Application No: BR/40/26/HH
Site Address: 94 Hook Lane Bognor Regis PO22 8AT
Description of works: Conversion of loft to habitable use with dormers and alterations to rear fenestration.

Thank you for your internet representation made on 20th May 2026 which has been recorded as no objection with the comments as follows:

NO OBJECTION

Proposed West Elevation

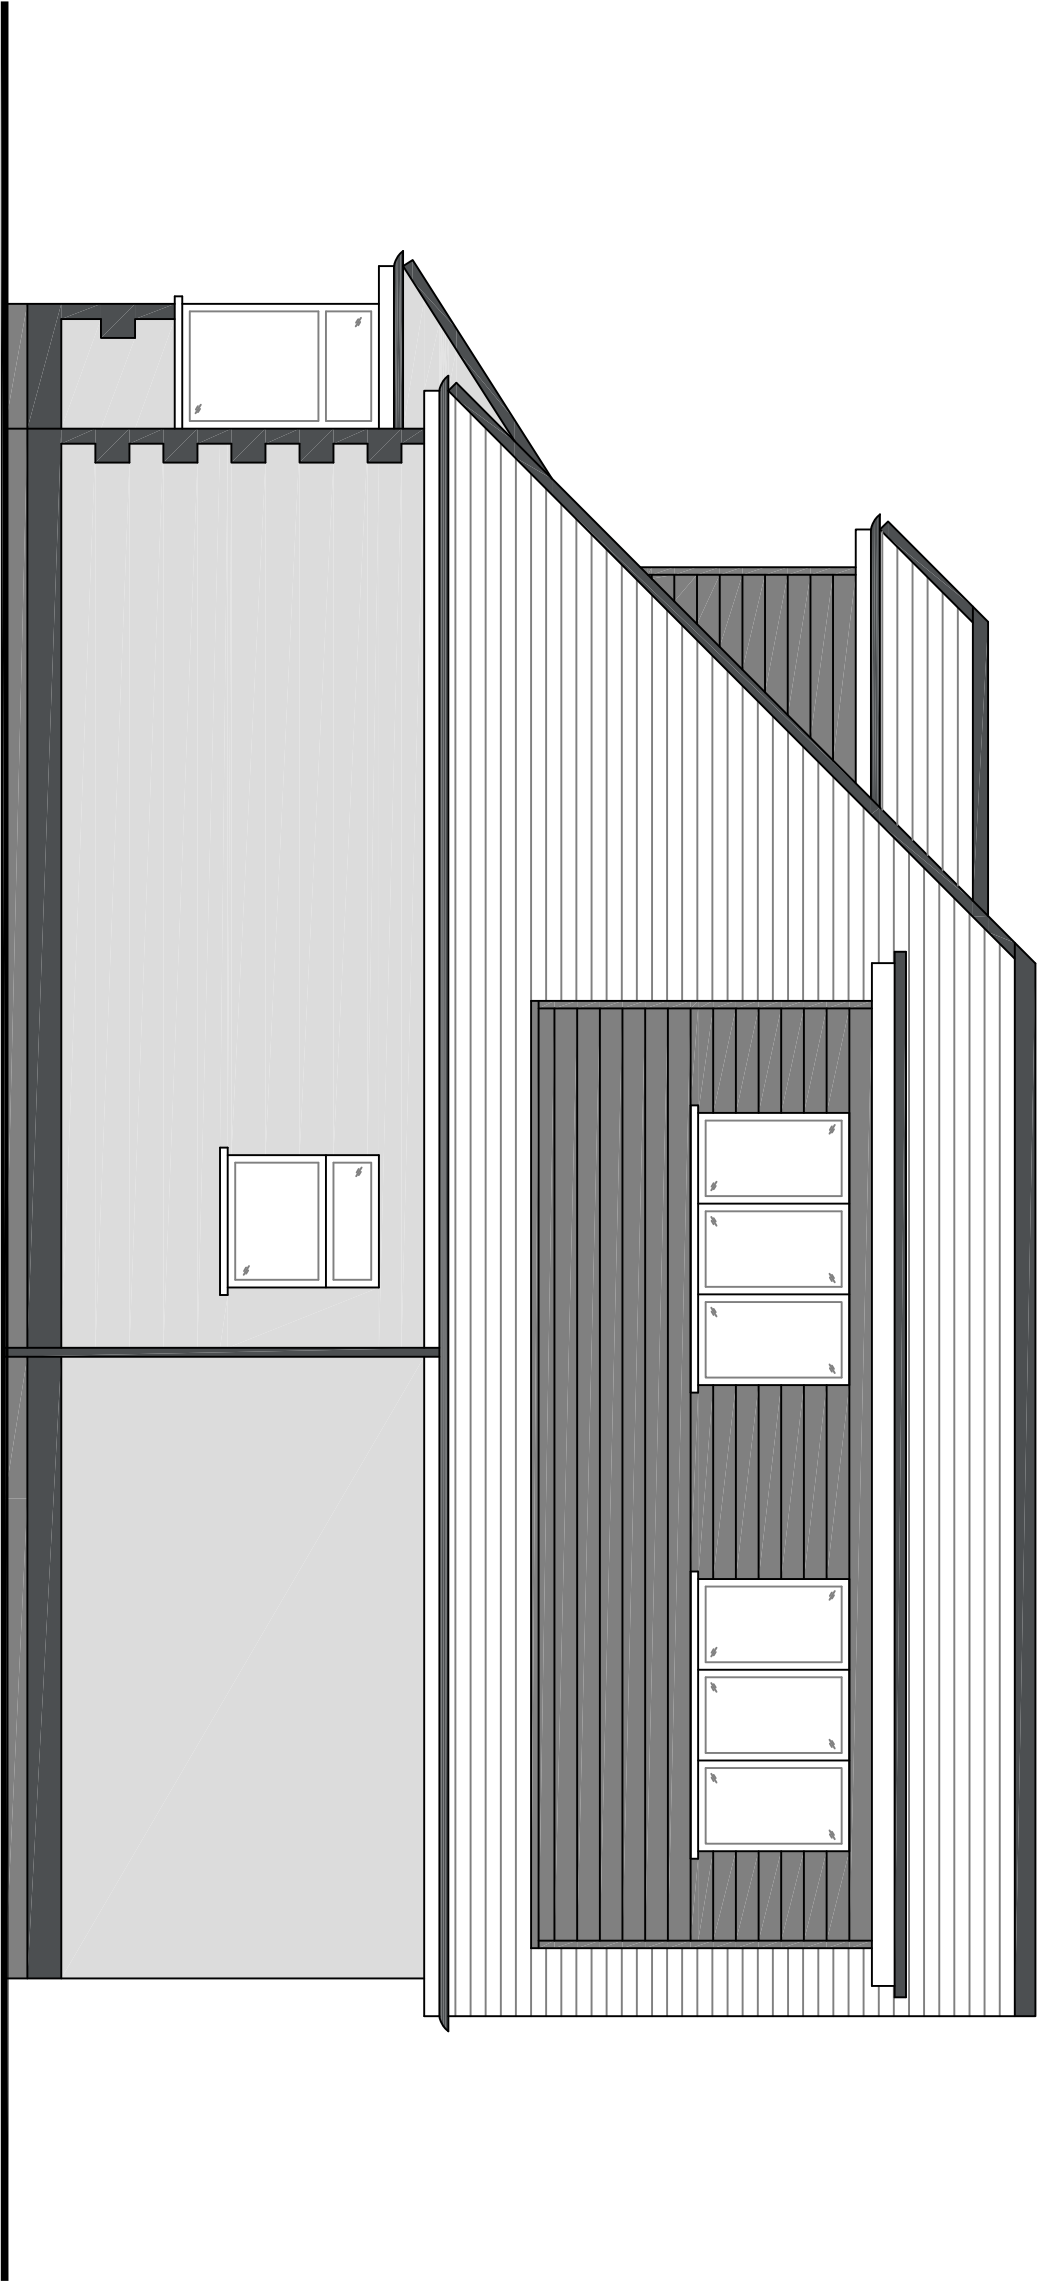
Members raised no objection to the application, however requested that a condition be applied to ensure that windows on the east and west elevations of the conversion do not result in overlooking of neighbouring properties, such as through the use of obscure glazing or raised window positions.
